Rezoning Transportation Analysis

Petition Number: 2023-091

Date	Description
9-28-23	First Review (NK)

STREET SECTIONS

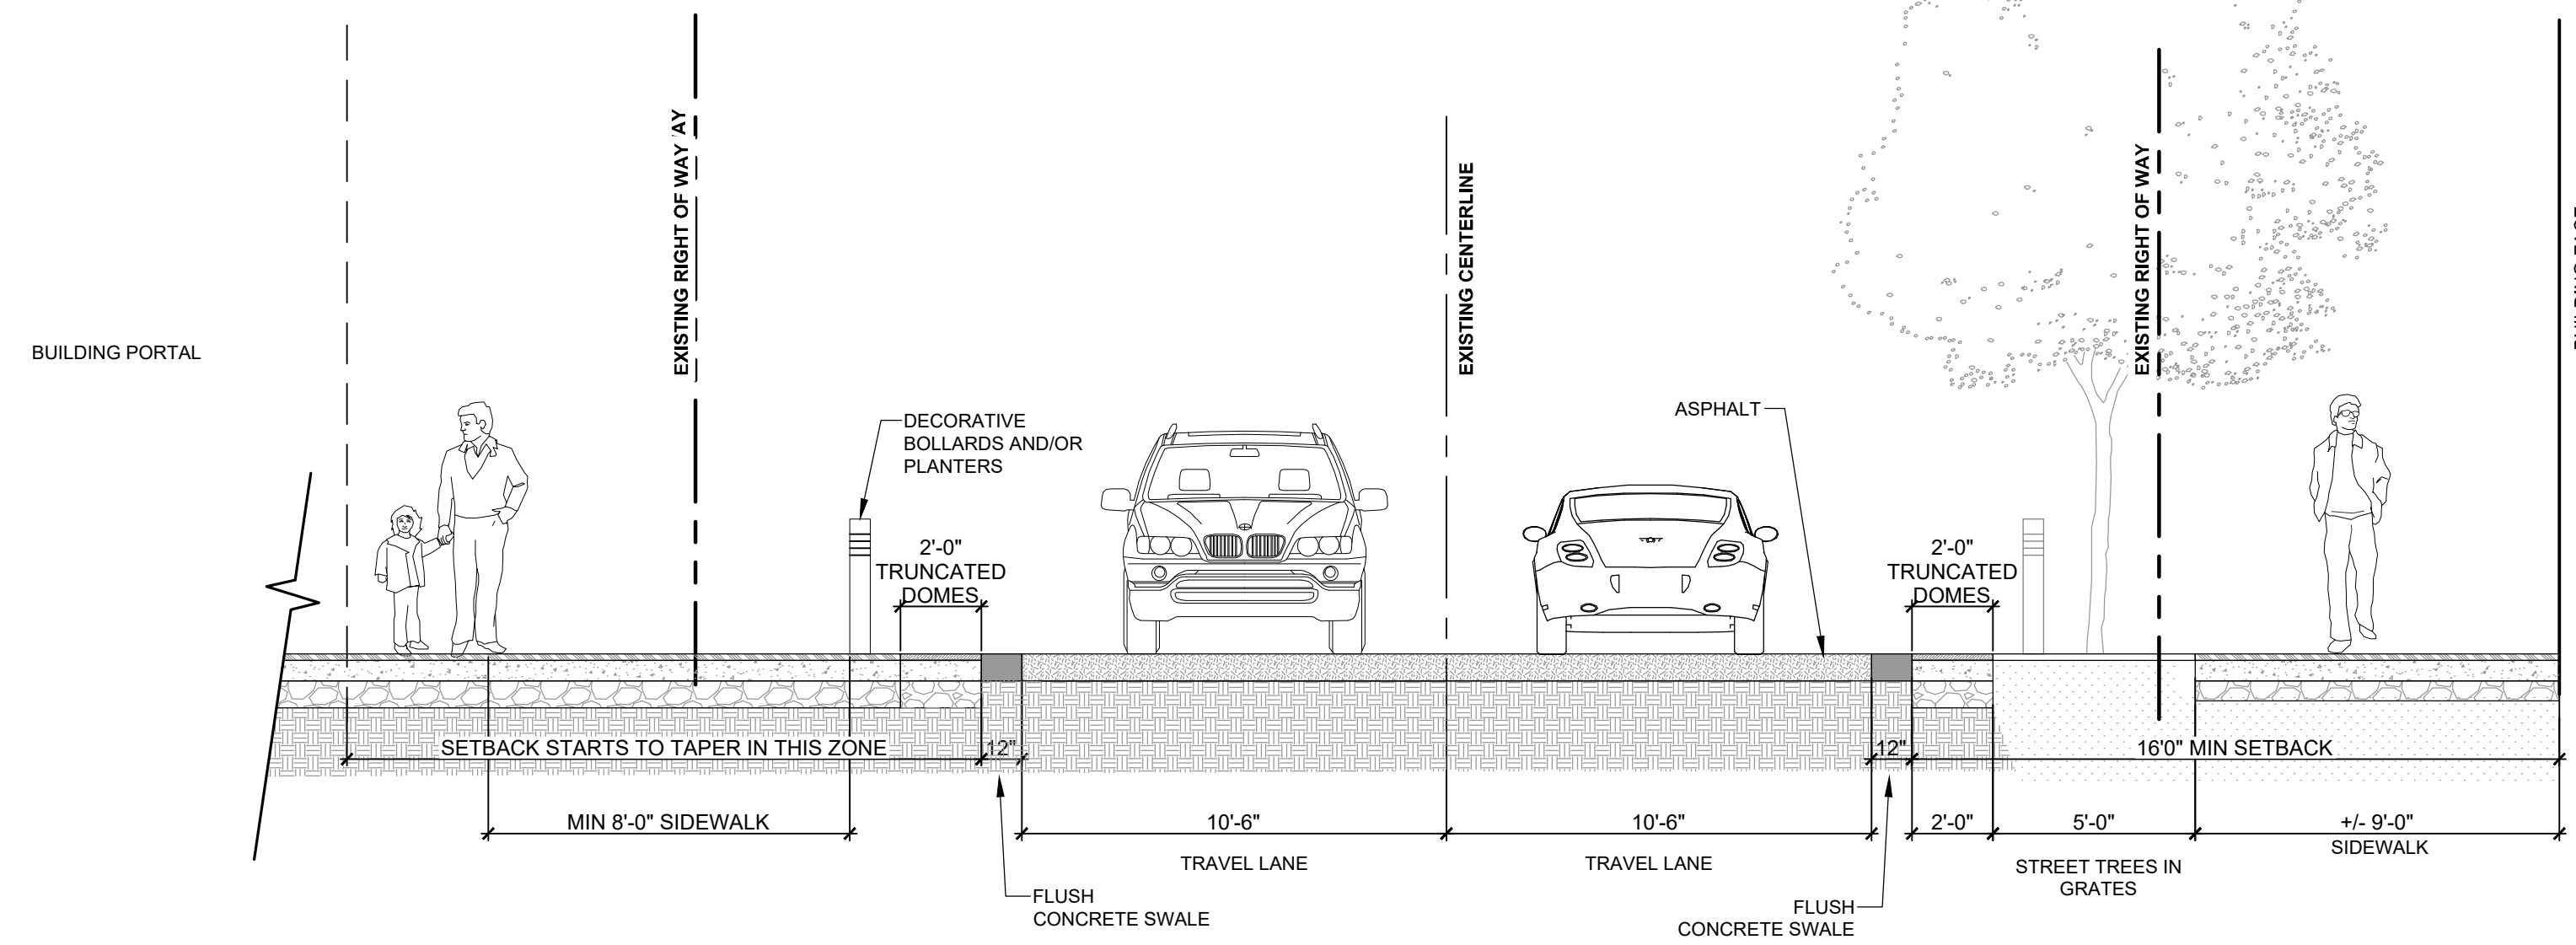
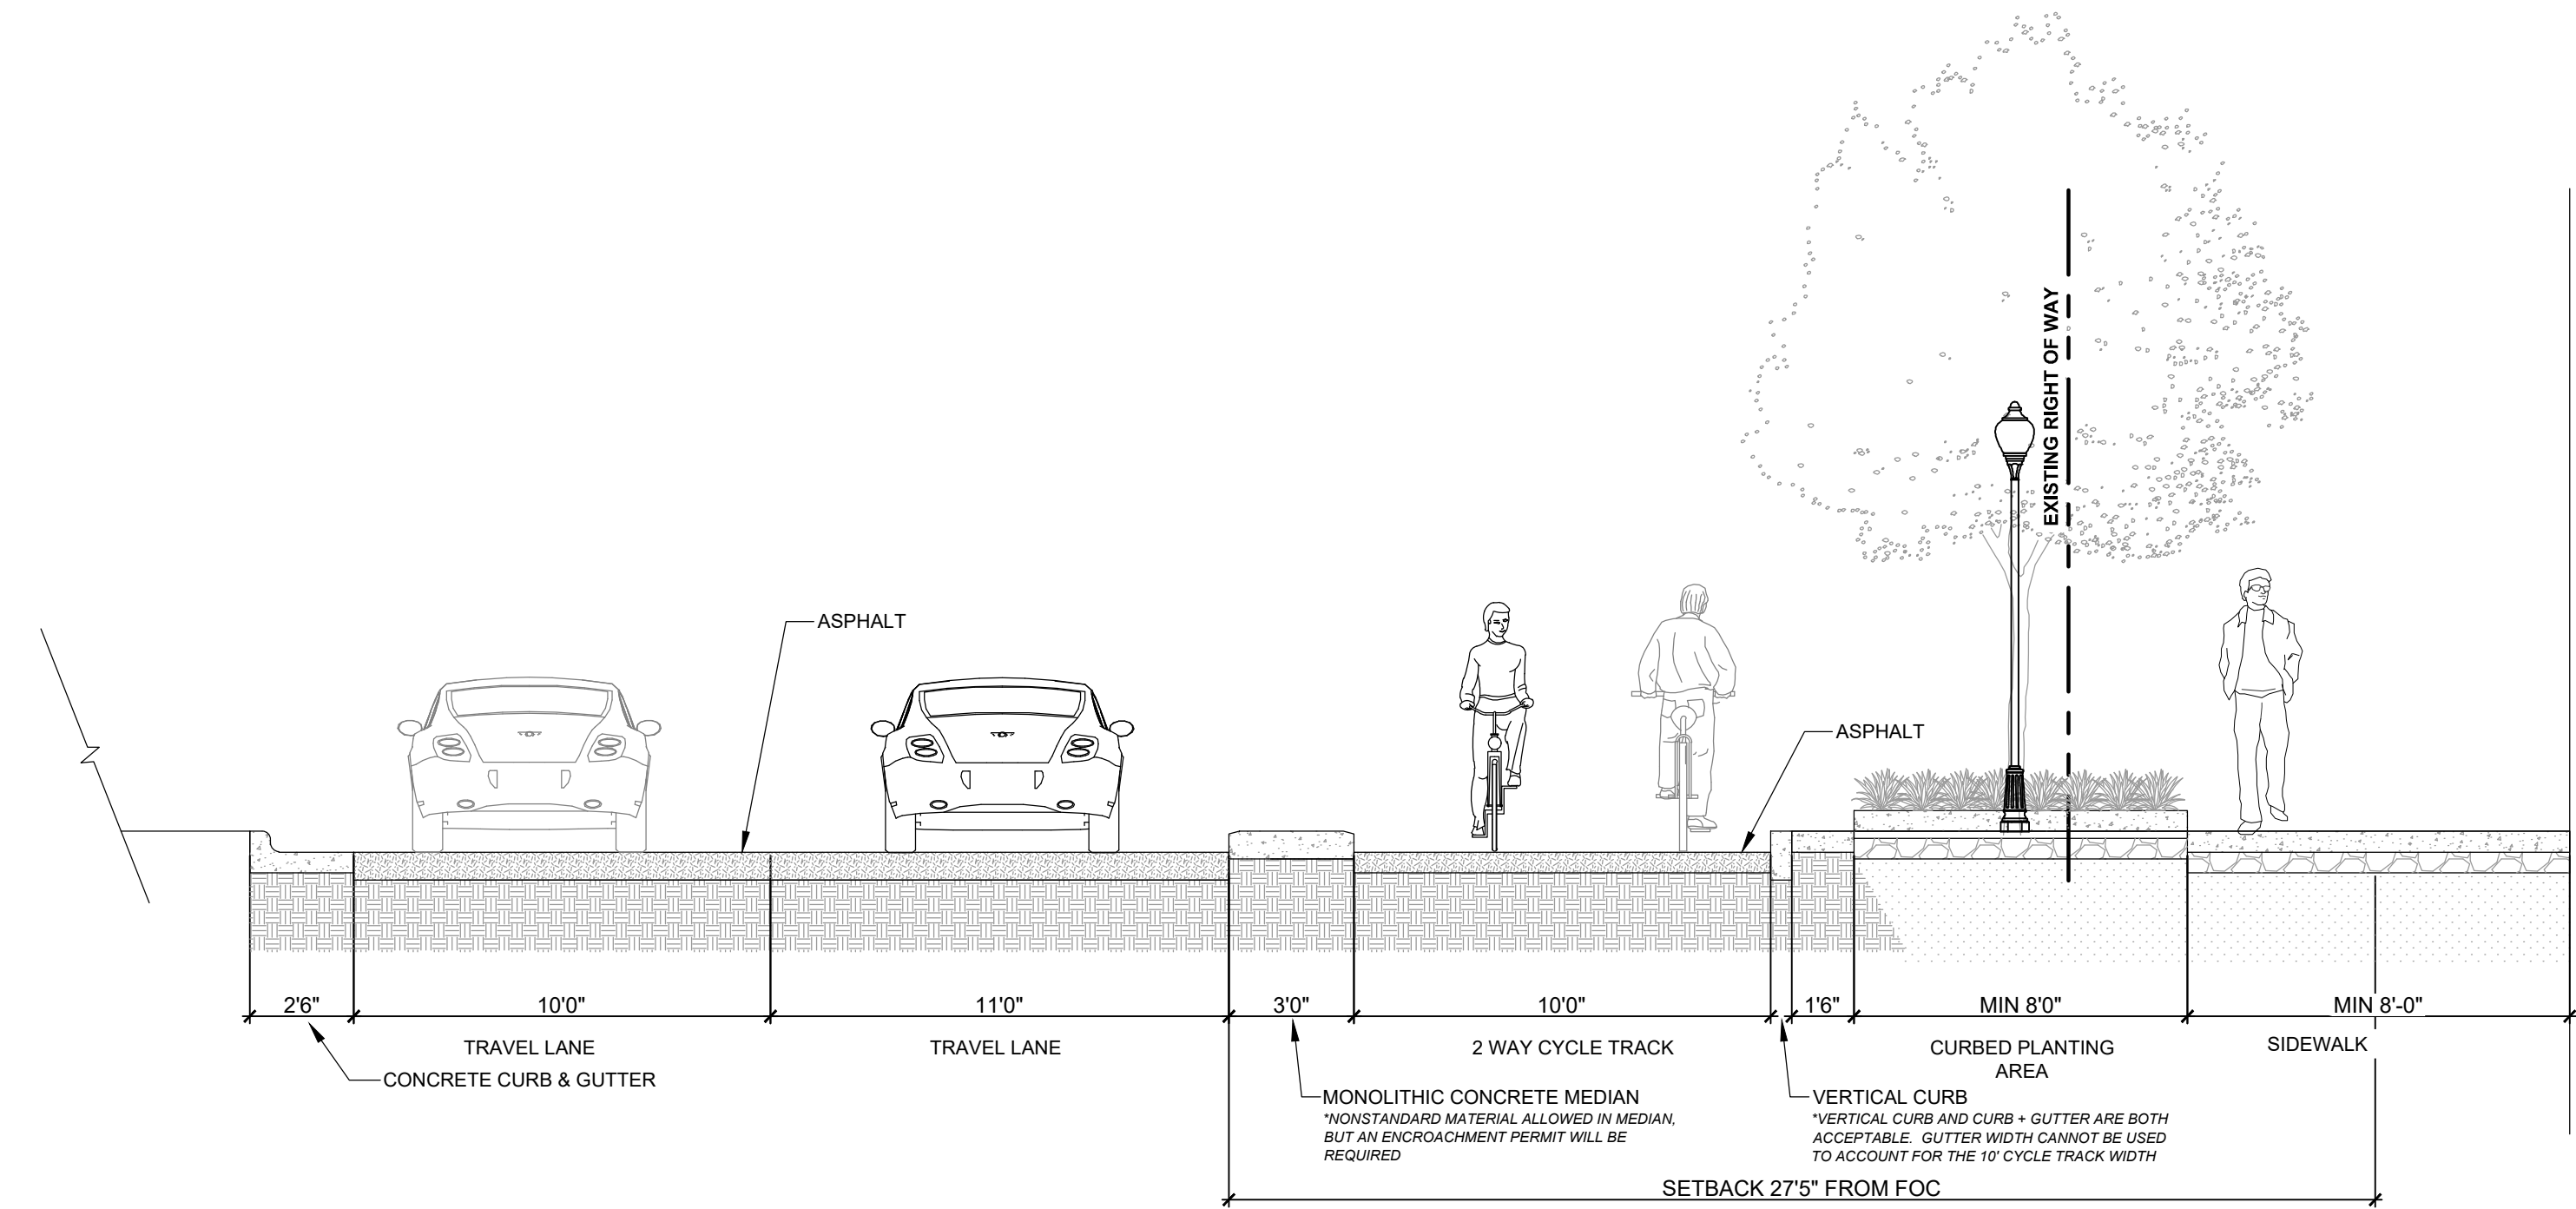
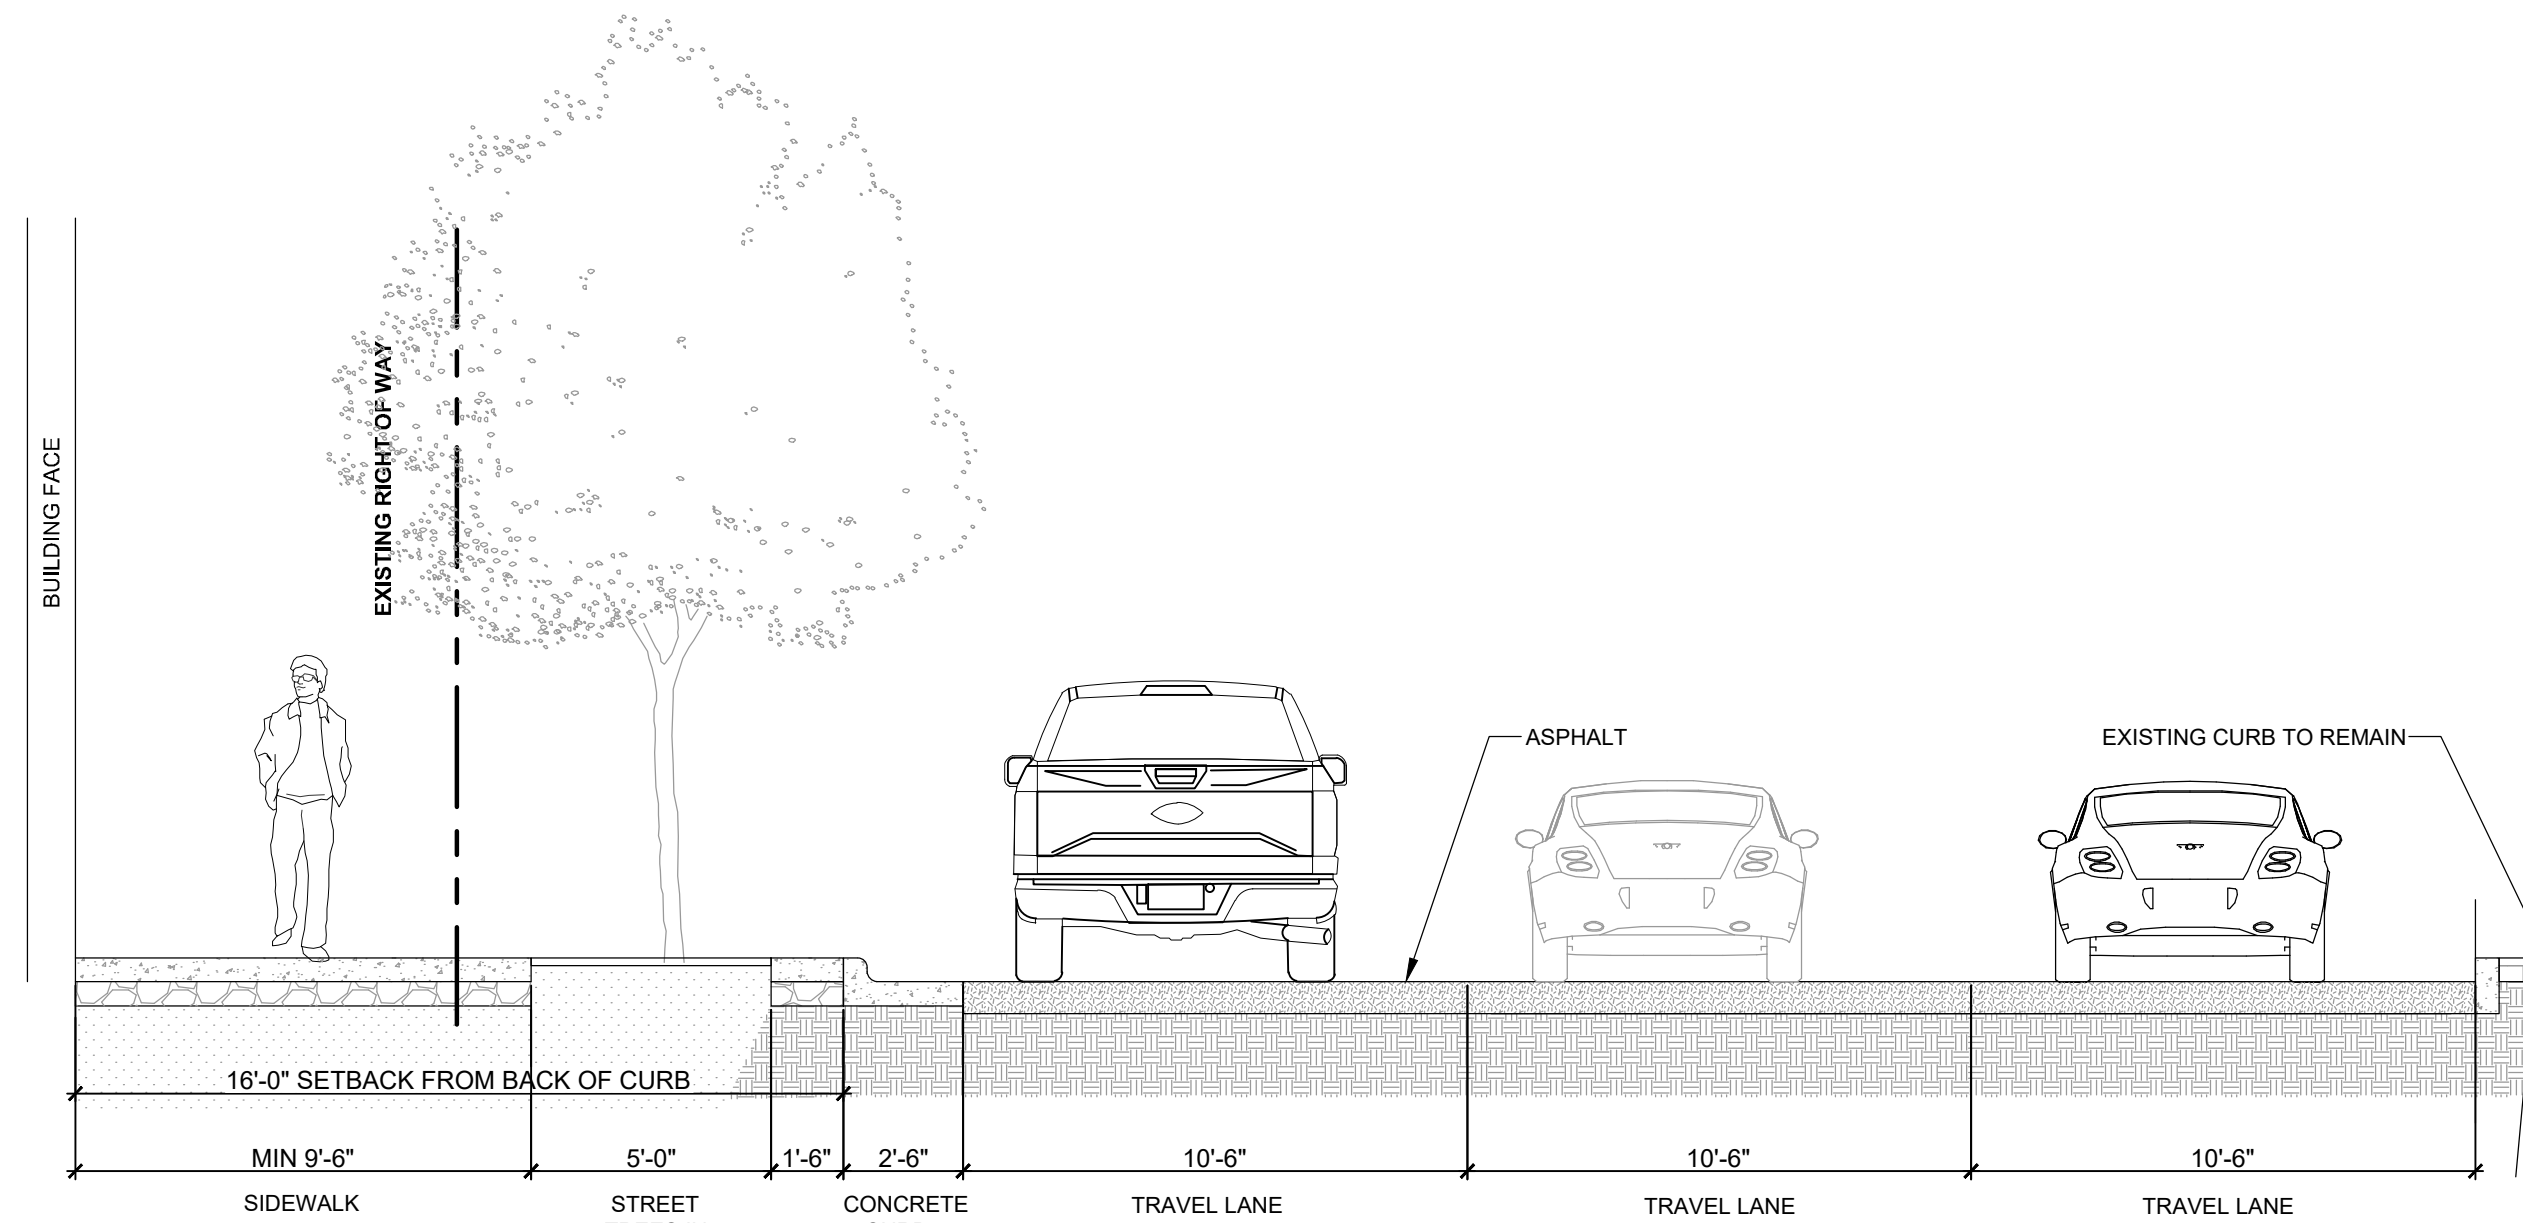
1. Curblines:

- a. **East 6th Street:** The future location of curb and gutter is in its existing location.

This street is an uptown primary street, and the cross section requires a 10' shared use path with an 8' amenity zone.

Label and dimension the curb and gutter from the centerline for each road on the site plan.

- b. **North Tryon Street:** The future location of curb and gutter is in its existing location.

This street is an uptown signature street, and the cross section requires a 12' shared use path with a 9.5' amenity zone.

Label and dimension the curb and gutter from the centerline for each road on the site plan.

- c. **North College Street:** The future location of curb and gutter is in its existing location.

This street is an uptown primary street, and the cross section requires a 10' shared use path with an 8' amenity zone.

Label and dimension the curb and gutter from the centerline for each road on the site plan.

- d. **East 7th Street:** The future location of curb and gutter is in its existing location.

This street is an uptown primary street, and the cross section requires a 10' shared use path with an 8' amenity zone.

Label and dimension the curb and gutter from the centerline for each road on the site plan.

4. Revise site plan and conditional note(s) to commit to construct bicycle facilities by installing a 10' multi-use path along East 6th street, North College Street, and East 7th Street. in accordance with the council-adopted Charlotte Streets Map. Multi-use paths maintained by the City shall meet ADA/PROWAG requirements.

5. Revise site plan and conditional note(s) to commit to construct bicycle facilities by installing a 12' multi-use path along North Tryon Street in accordance with the council-adopted Charlotte Streets Map. Multi-use paths maintained by the City shall meet ADA/PROWAG requirements.
